Consultation Response from KC Highways Development Management**2019/93444 land at former, Batley & District Cottage Hospital, Transvaal Terrace, Carlinghow Hill, Batley, WF17 0AA****Partial demolition of existing building, alterations to convert retained building to 20 apartments and erection of 20 dwellings (within a Conservation Area)****Date Responded:02-12-2019****Responding Officer: Mark Berry****Responding Ref: 13-07SE/7**

This application seeks approval to the partial demolition of an existing building, alterations to convert retained building to 20 apartments and erection of 20 dwellings at land at former, Batley & District Cottage Hospital, Transvaal Terrace, Carlinghow Hill, Batley

Figure 3.2: Transvaal Terrace/Carlinghow Hill Improvement

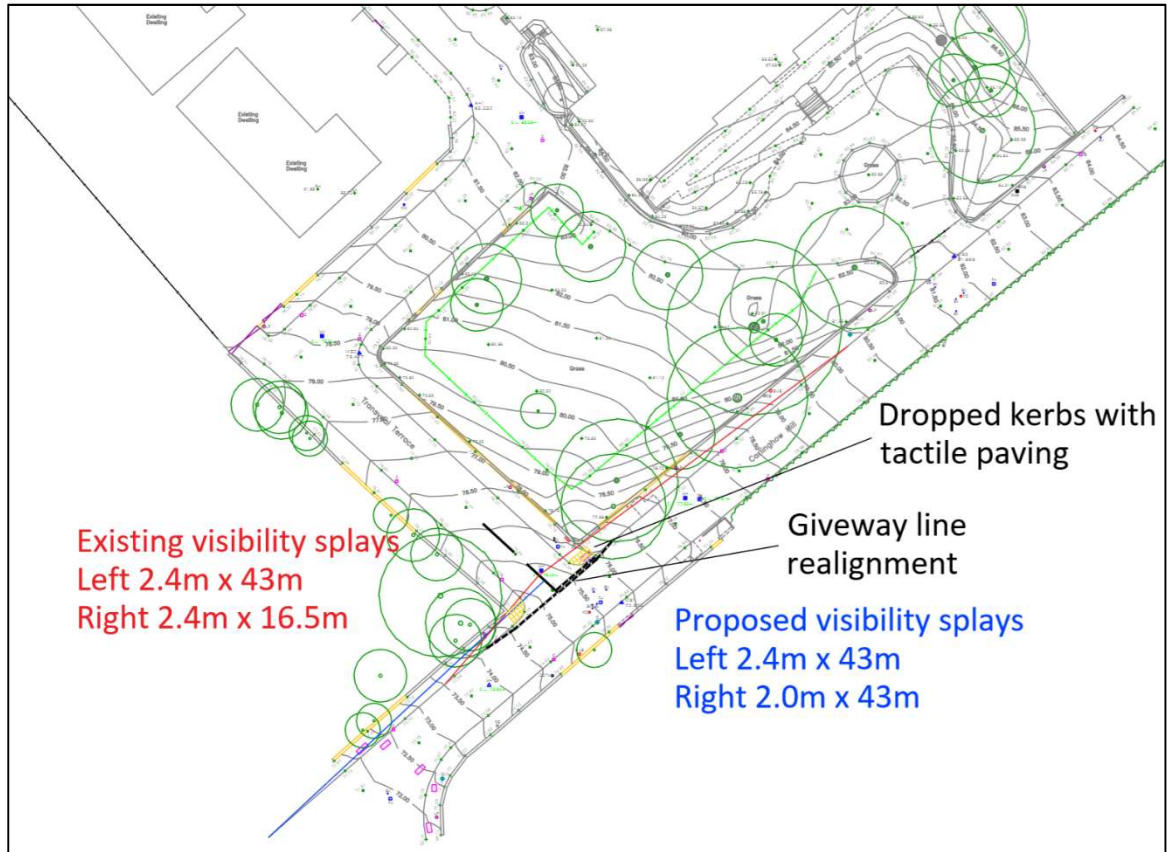
Improvements are shown at the junction of Transvaal Terrace and Carlinghow Hill to improve visibility at the junction. It is unlikely that the carriageway along this section of Carlinghow Hill could be narrowed and the proposed works may not therefore be considered acceptable. Pedestrian links could be improved with the provision of dropped crossings at the junction and the continuation of the areas of footways along the length of Transvaal Terrace which are currently missing.

Figure 3.3: Housing Turning Head Tracking

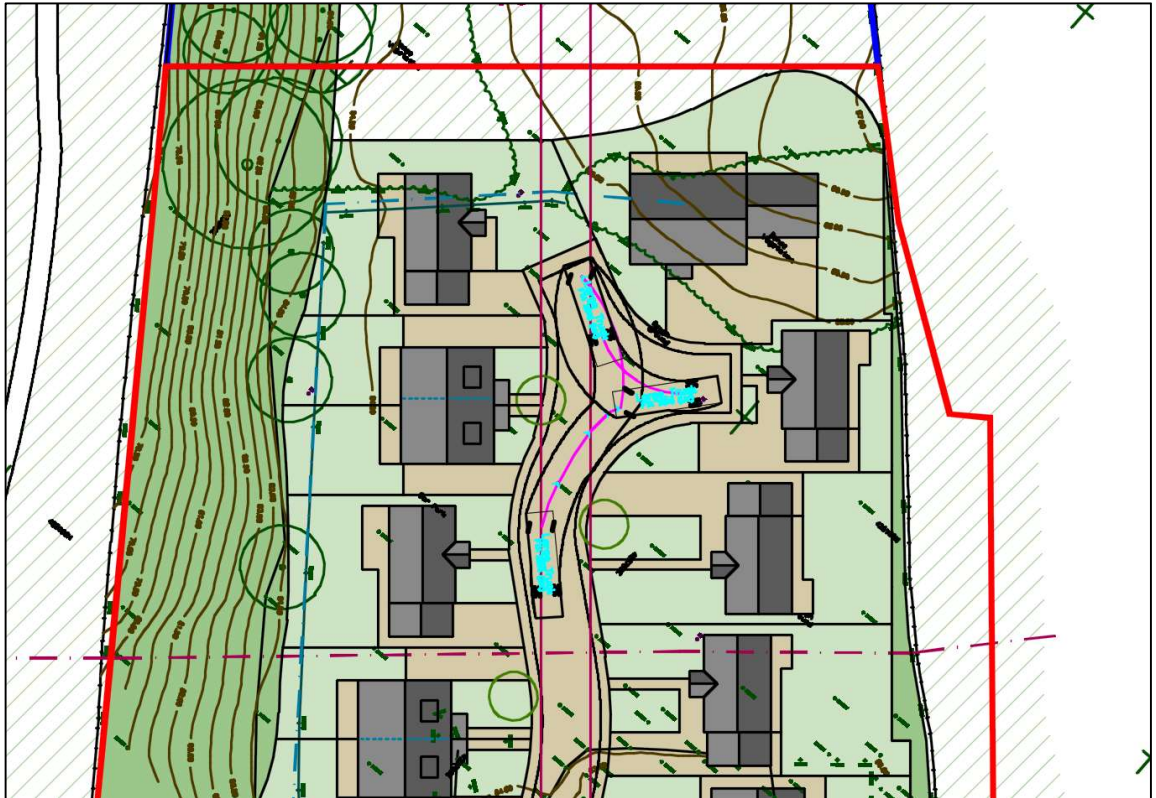
Swept paths are required to demonstrate that an 11.85 refuse vehicle can enter and exit the site from Carlinghow Hill and turn within the site.

18007-D02-A

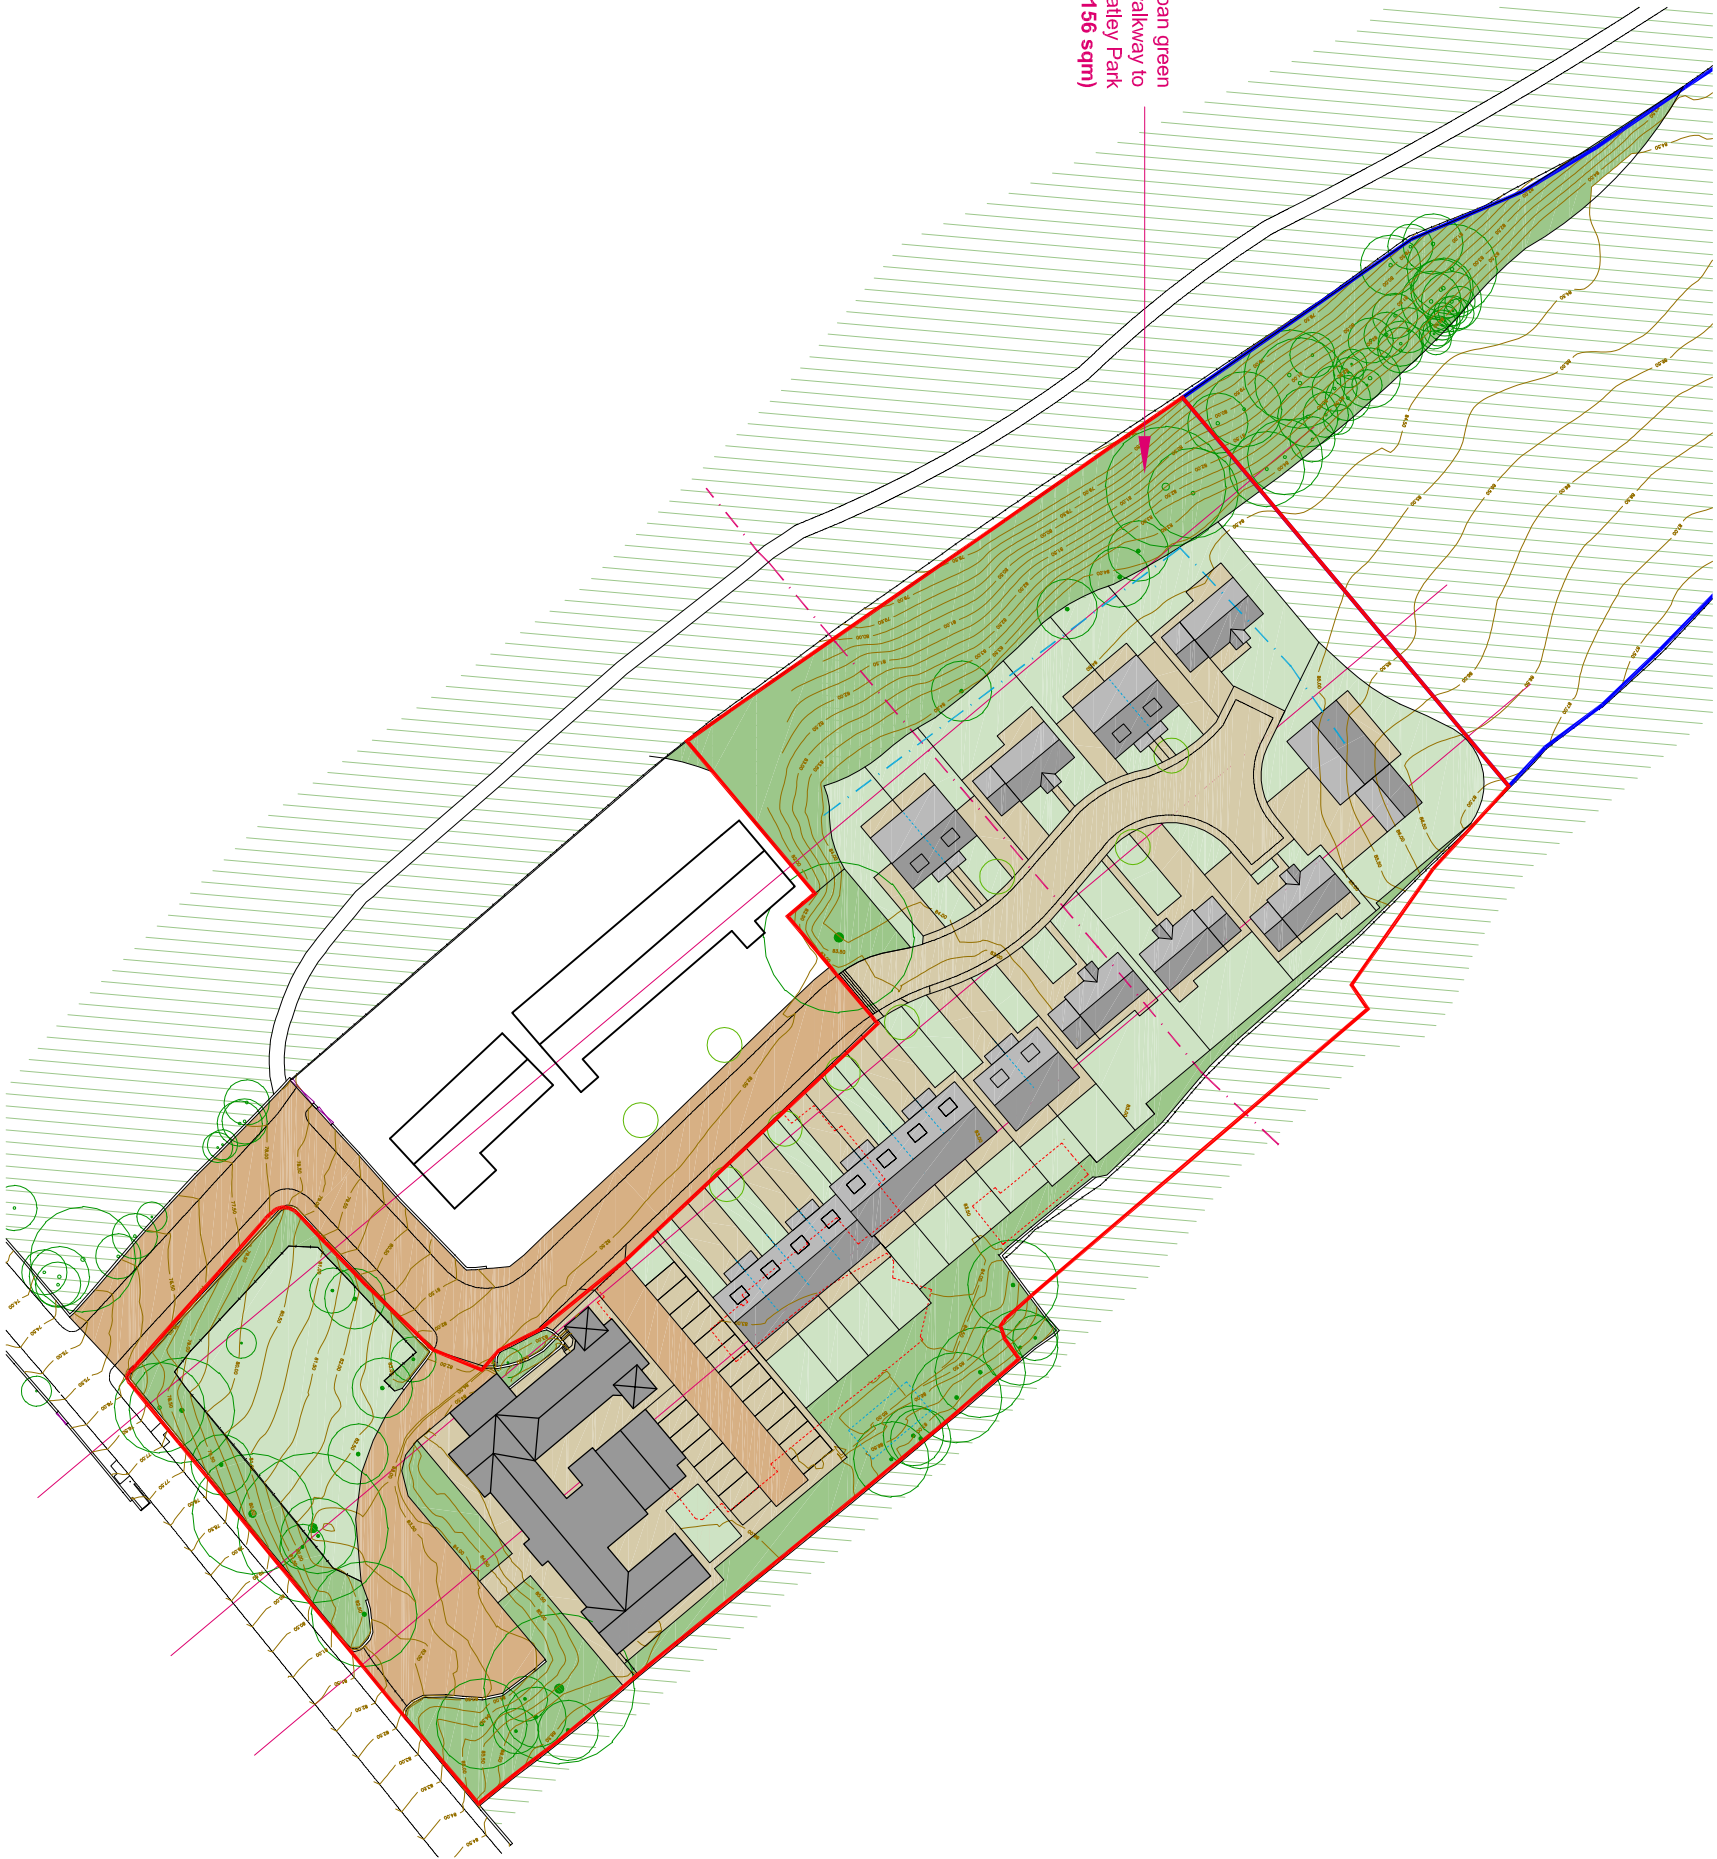
House type 1 is a 4 bedroomed dwelling with attached garage. The proposed garage is 5.19 x 2.85m in size which is less than the recommended 6.0 x 3.0m to be counted as a parking space. 3 out of the 5 plots have only one space on the proposed driveway to the frontage. The parking to these plots is therefore considered sub-standard. Three parking spaces are recommended to all of the type 1 houses which shouldn't include the garage given that it is insufficient in size.

There are 5 three bedroomed flats. Only 21 parking spaces are proposed for the proposed flats. Two spaces is recommended for the 3 bedroomed apartments. The proposed parking for the 20 flats is therefore considered sub-standard. HDM consider that 25 spaces should be provided for the flats plus visitor parking at a rate of 1 per 4.

The footways to either side of the proposed road should carry 2 metres past the proposed ramp at the transition between the existing traditional estate road and the shared surface carriageway.

The shared surfaces should be re-designed to be more angular with alignment shifts.

No longitudinal sections are provided to show the proposed gradients to the proposed adoptable highway.

Bin presentation points should be shown which should be positioned such that bins can be left out for collection without either obstructing the private driveway or the public highway.
